From: [marianne leslie](#)
To: [Deb Estrada](#)
Cc: [marianne leslie](#)
Subject: SUB19-002
Date: Tuesday, January 23, 2024 9:00:33 PM

SITE PLAN
2825 W MERCER WAY
PRELIMINARY PLAN
PARCEL #2174502425
CITY OF MERCER ISLAND WASHINGTON

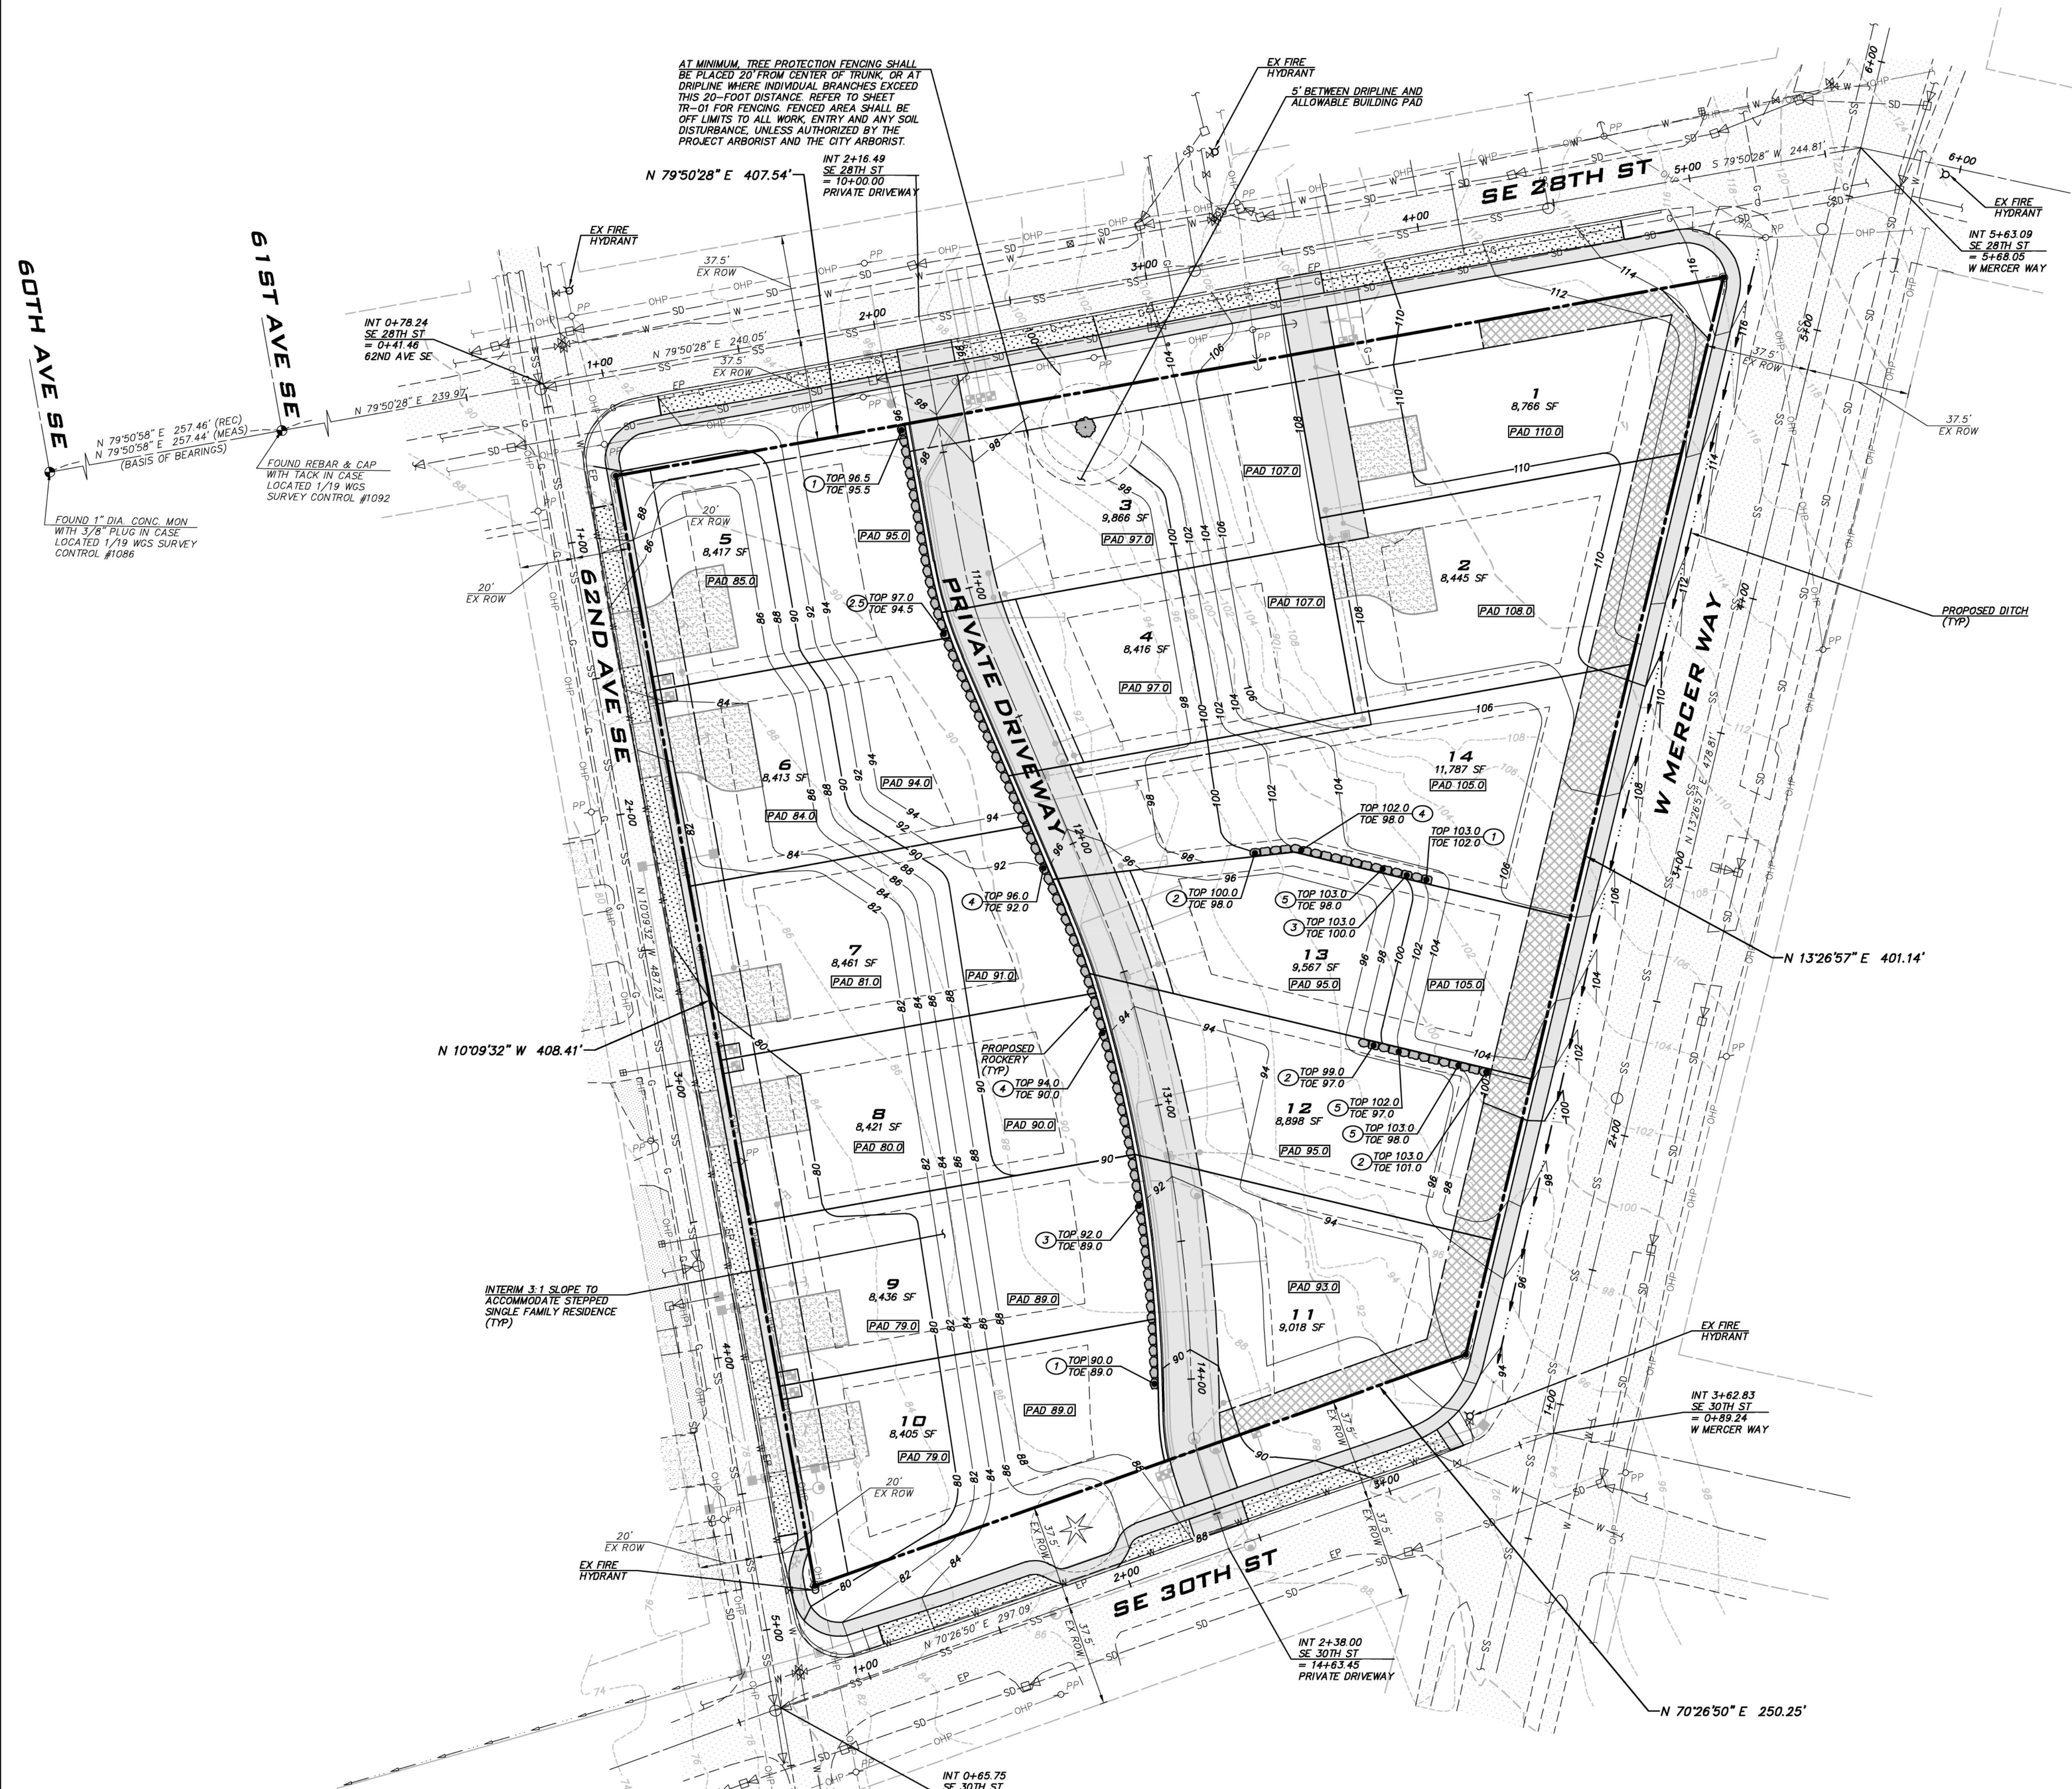
8. Six of the proposed lots along 62nd Ave SE currently have driveway access from outside of the new community and along 62nd Ave. This makes no sense and will negatively affect those existing homes on 62nd Ave. Why are those driveways NOT required to be inside the community and accessed from the new private driveway? Where would guests, trades, repairmen, housekeepers, and vendors park when going to these 6 new homes. It is unconscionable and a grave

mistake to not require these 6 driveways to be inside the community with driveway access from the private driveway.

If the City allows these driveways to be outside of the community, then the City is not representing everybody equally who will be affected by this development, and doing a disservice to those existing families and homes along 62nd Ave.

PRELIMINARY UTILITY PLAN
2825 W MERCER WAY
 PRELIMINARY PLAT
 PARCEL #2174502425
 CITY OF MERCER ISLAND WASHINGTON

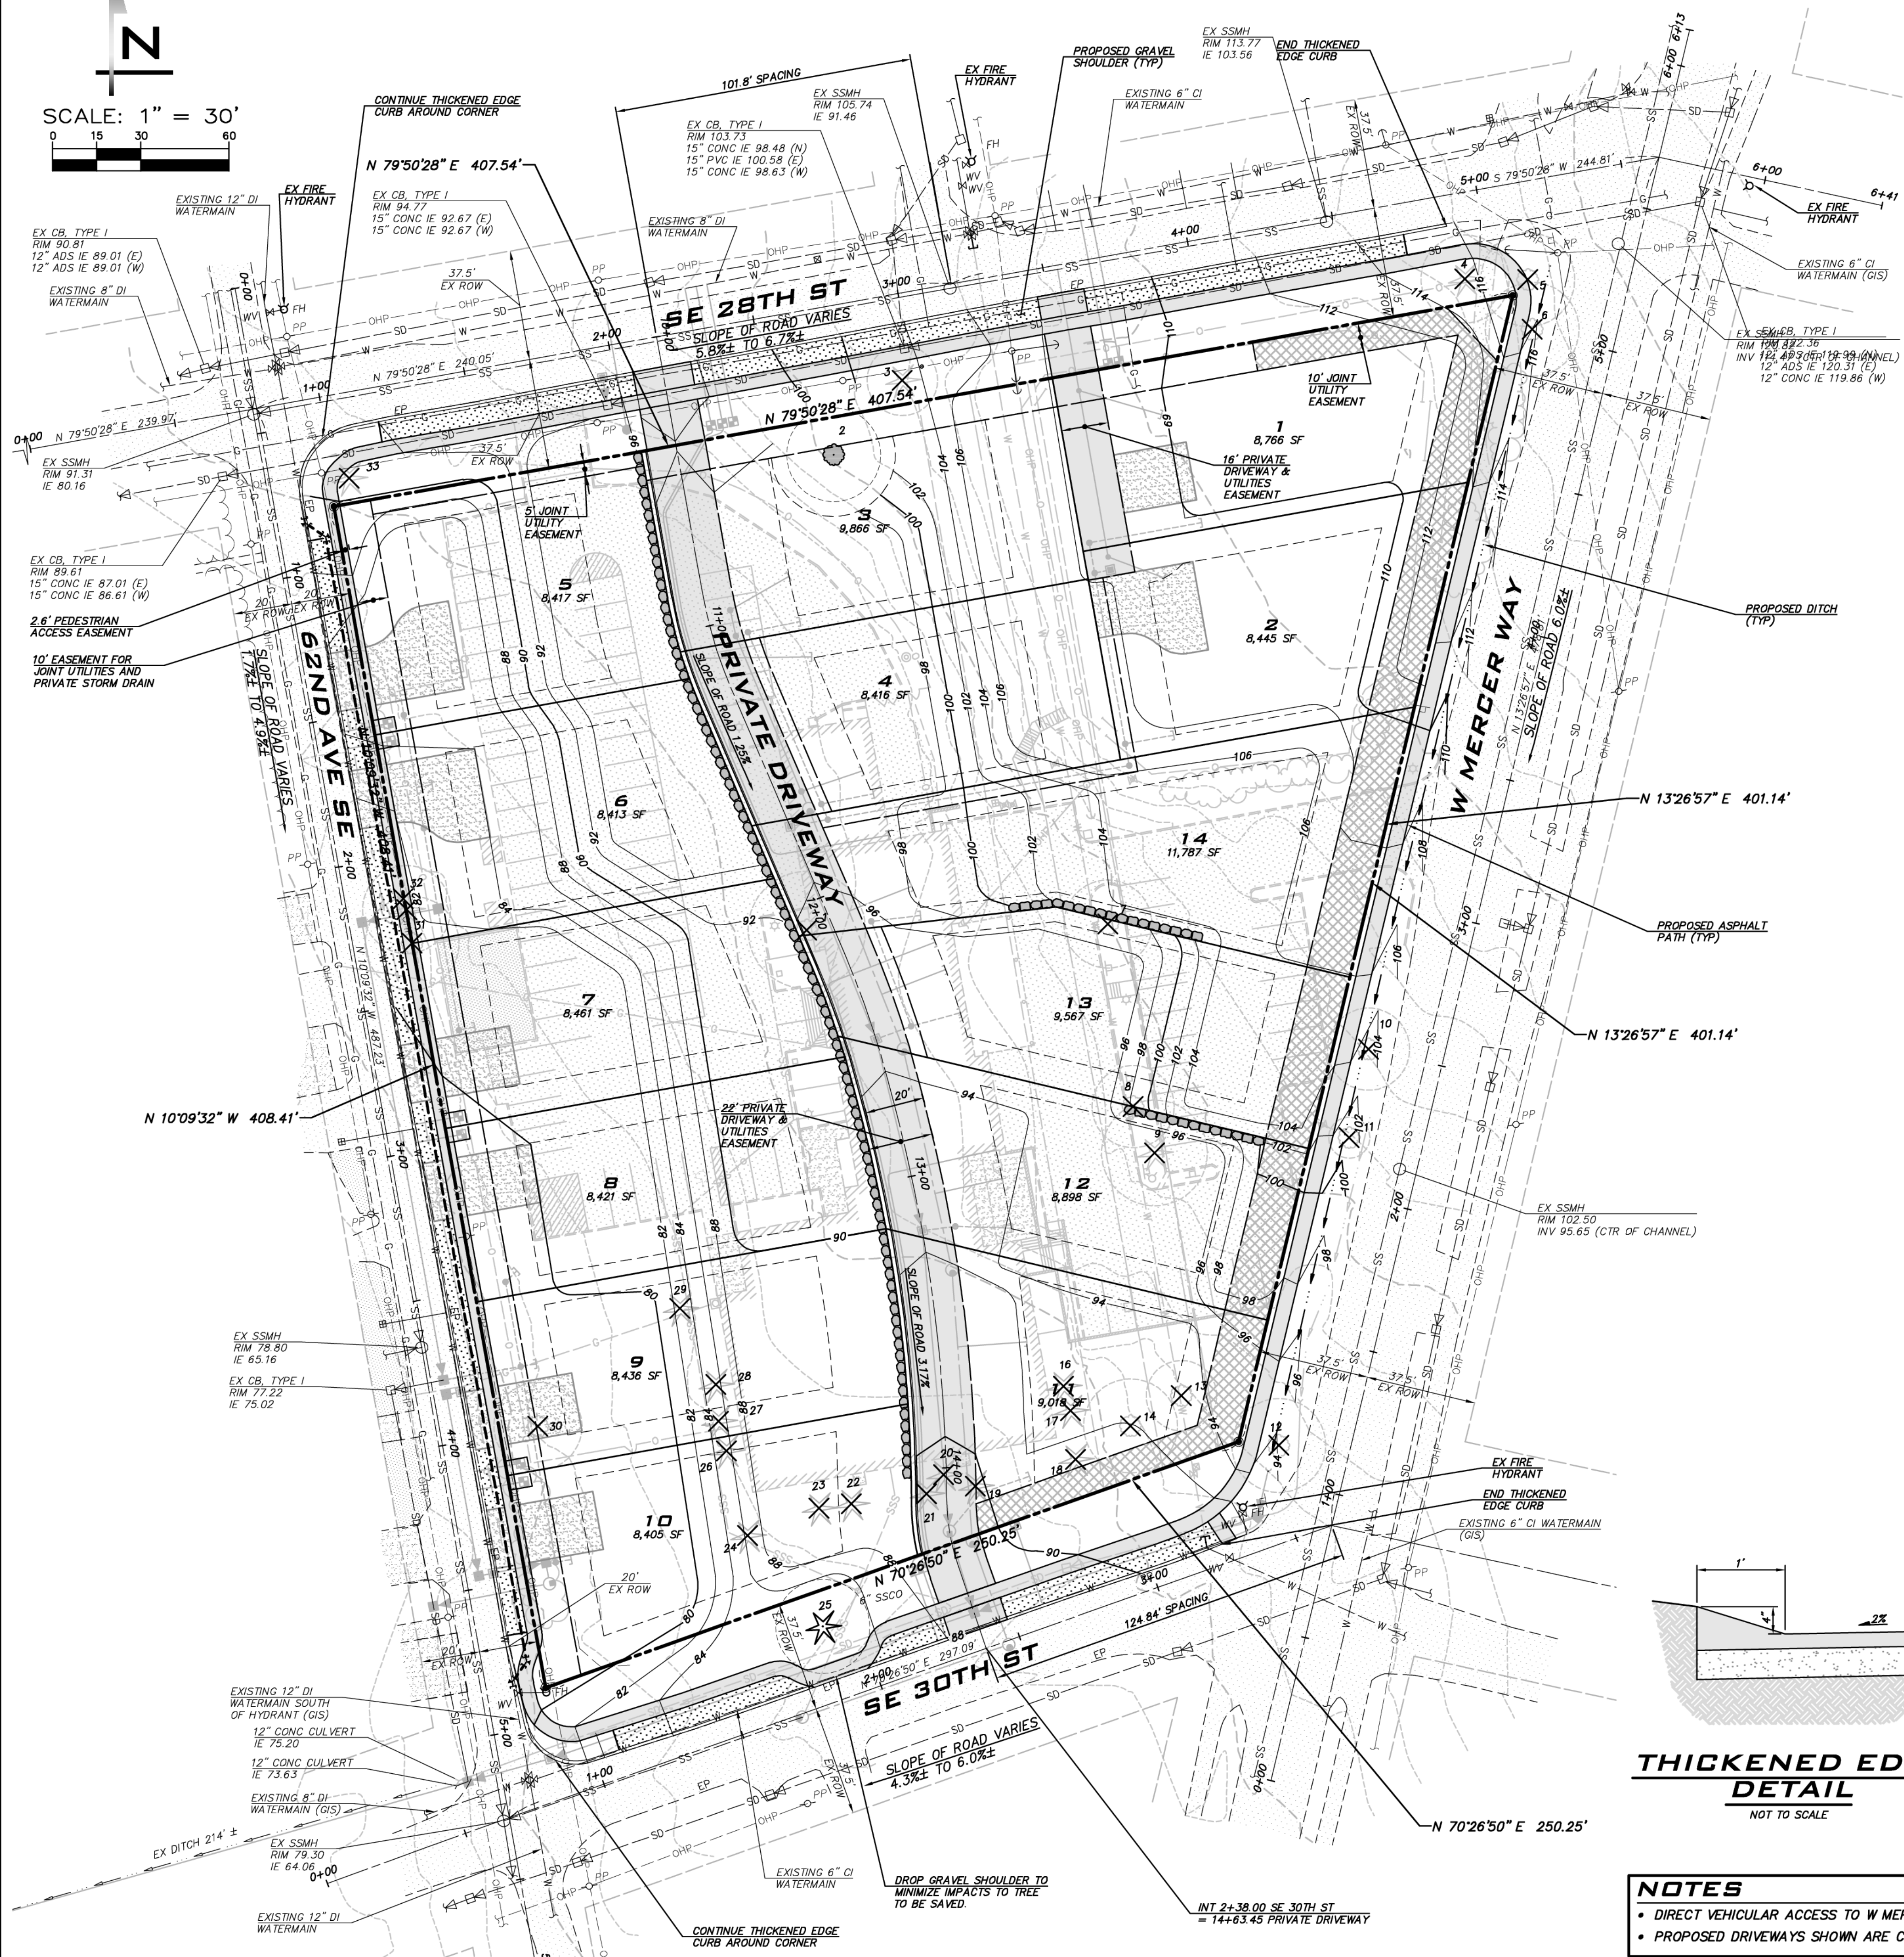
1. Appears that utilities will be underground, and I thank the owner/developer for doing that. The last thing Mercer Island needs is more power poles.
2. I did not see a drainage or sedimentation pond where water will be filtered prior to draining into storm drains and eventually emptying into to Lake Wash. Did I miss that? How does this fit with environmental issues and doing the right thing for the environment? Most all long plats in King County are now required to construct these drainage or sedimentation ponds. Why isn't Mercer Island aligned with that requirement, especially with a proposed development only two blocks from Lake Wash?
